Rezoning Transportation Analysis

Petition Number: #2022-109

Date	Description
11-28-22	First Review (IW)
12-21-22	Second Review (IW)
01-25-23	Third Review (TM)
03-22-23	Forth Review (IW)
09-25-23	Fifth Review (IW)

TECHNICAL  
DATA SHEET

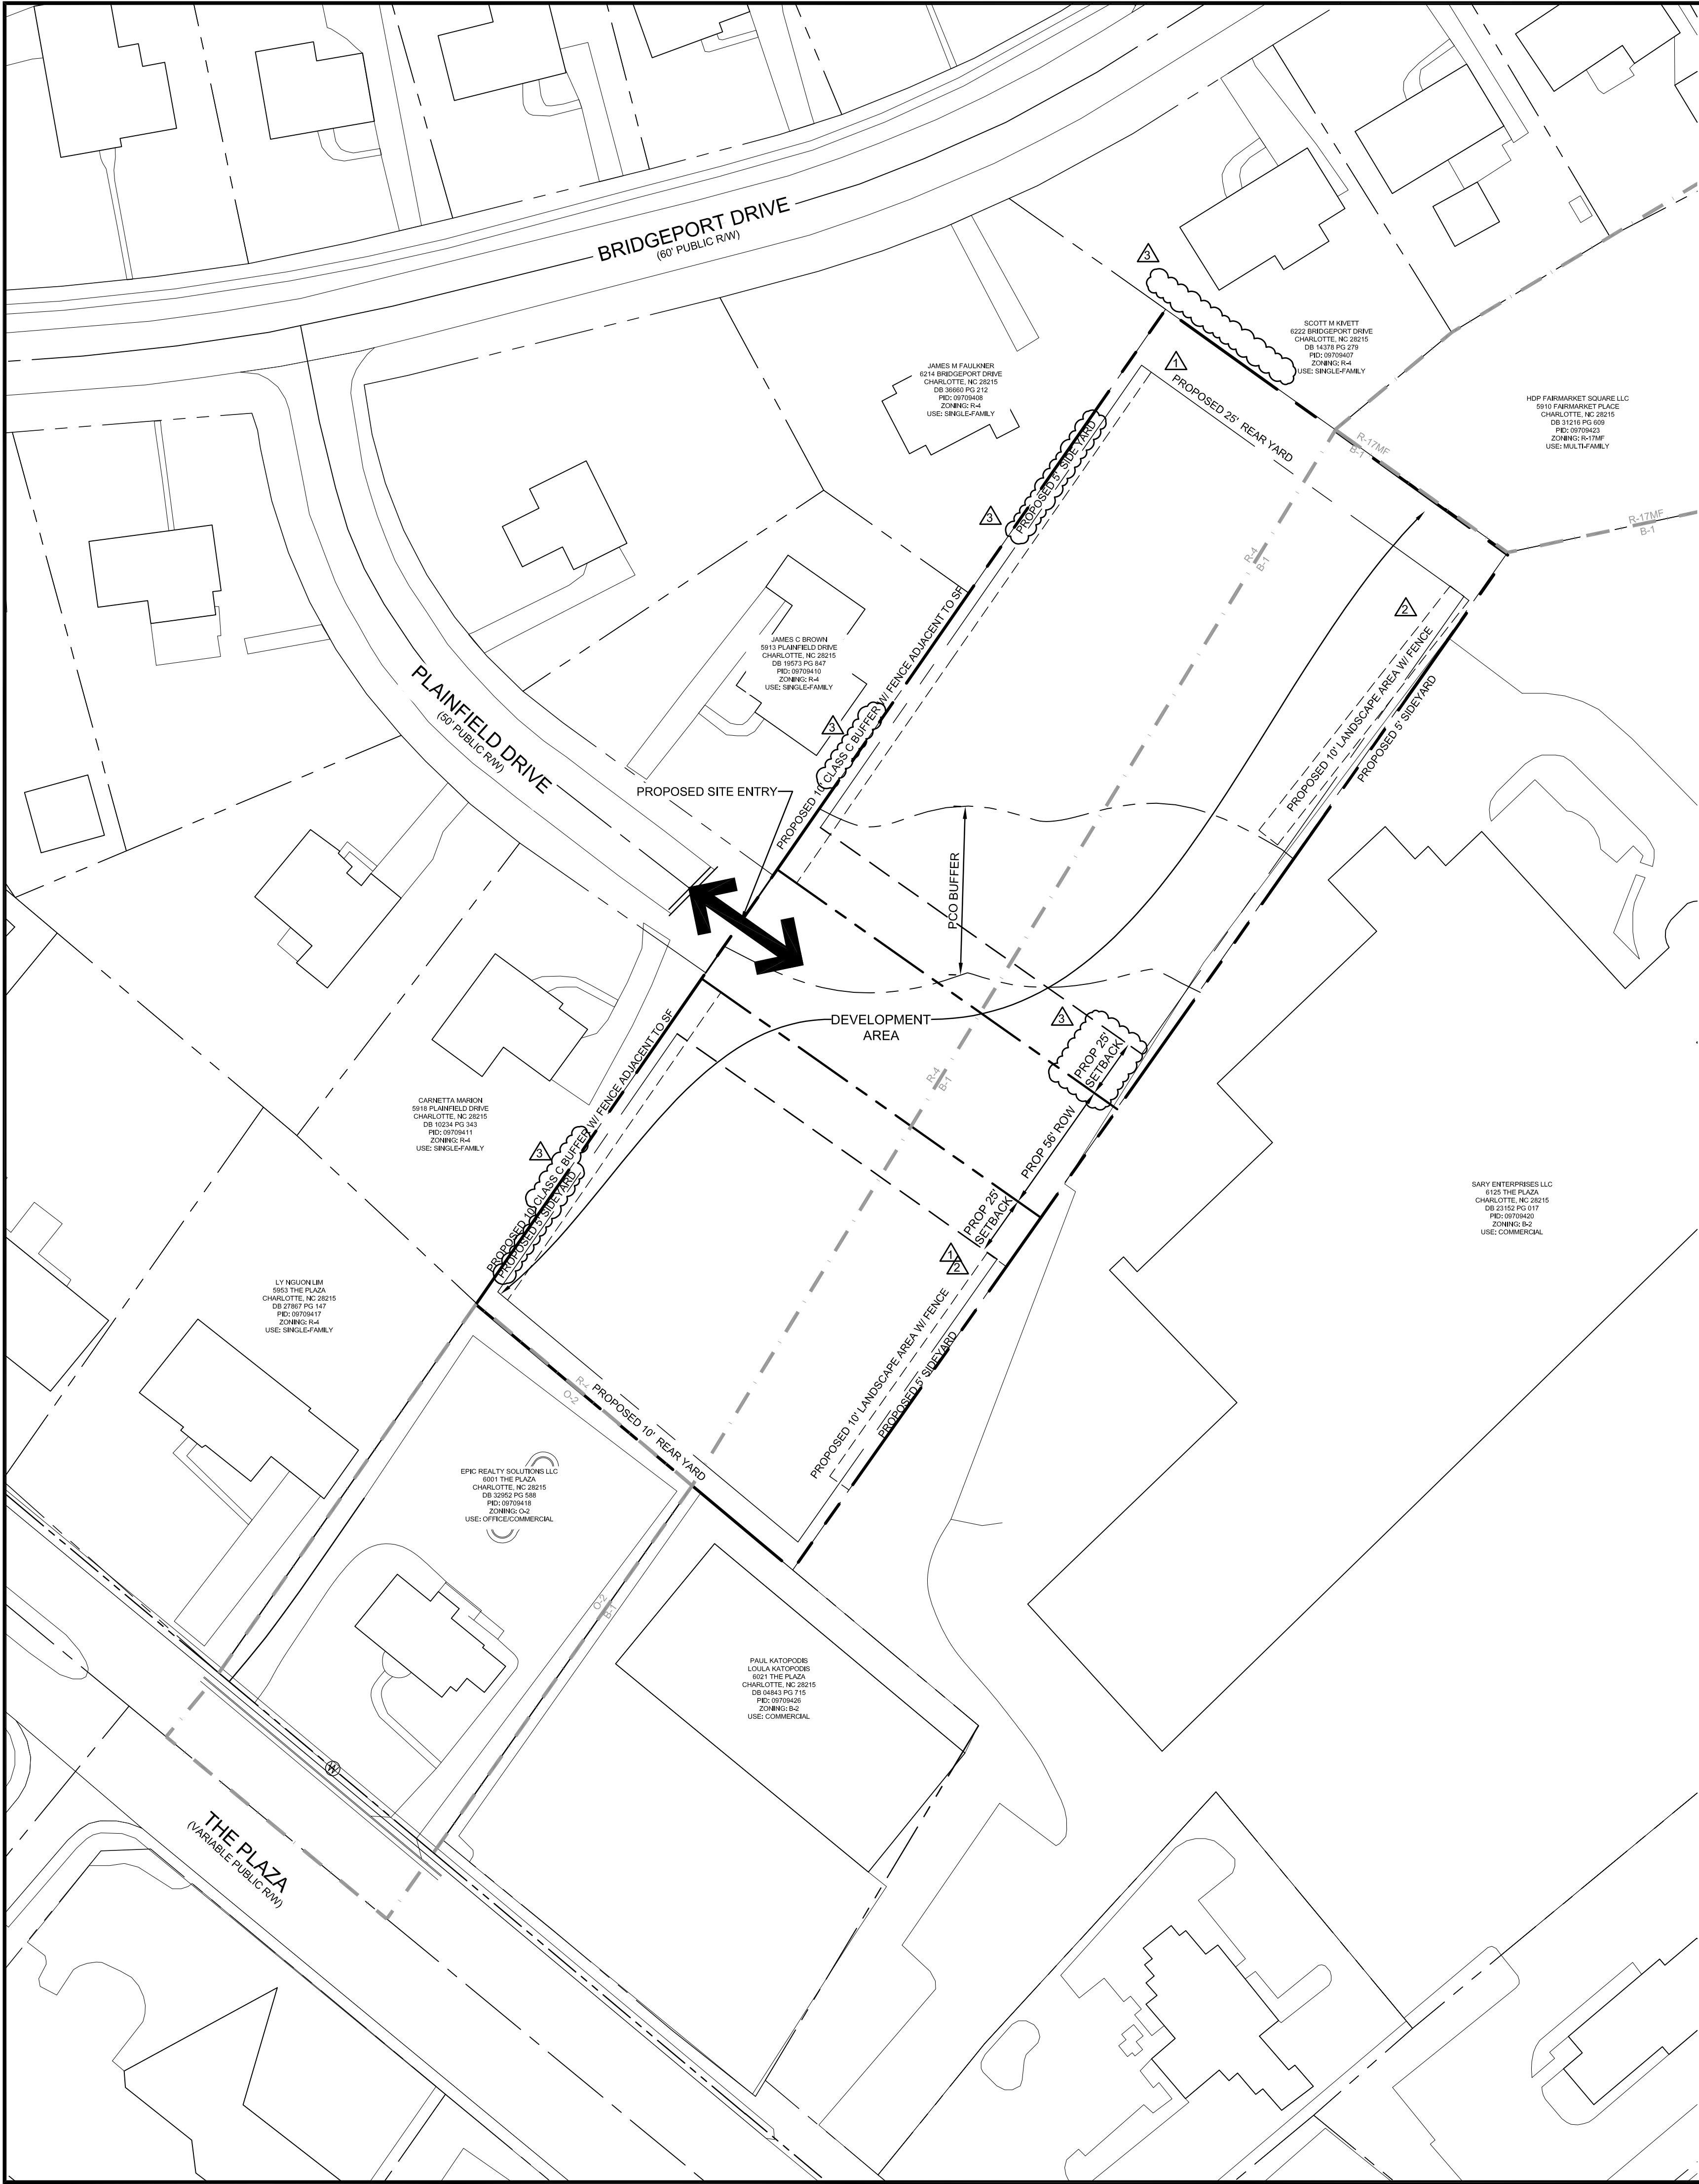
1. ~~**Curblines:** The proposed zoning district has a setback measured from back of the existing or proposed future curblines.~~
 - a. ~~**Plainfield Drive:** The future location of curb and gutter is in its existing location.~~

~~Label and dimension the curb and gutter from the centerline for each road on the site plan.~~

3. ~~Revise site plan and conditional note(s) to commit to construct an 8-foot planting strip, and 8-foot sidewalk on both sides of all public roads per Chapter 20. The site plan shall label and dimension both items from the back of curb and gutter and road centerline.~~

4. ~~The proposed dwelling units exceeds 12 per acre. Per Chapter 20 Subdivision ordinance, site plan and conditional note(s) revisions are needed to commit to construct an 8-foot planting strip, and 8-foot sidewalk along all public roads. The wider sidewalk also meets the Charlotte WALKS Policy.~~

~~Reference (CLDSM standard detail U-02) for residential medium street typical.~~

~~**Outstanding Clarifying Comment 12-21-22:** Petitioner should add conditional note stating commitment of 8' planting strip and 8' sidewalk along both sides of all public roads. Reference (CLDSM standard detail U-02) for residential medium street typical section. Potential environmental conflicts to be coordinated during permitting if full section cannot be achieved.~~

5. ~~Revise the plan and conditional note(s) to commit to designing the end of the proposed extension of Plainfield Drive as street stub.~~
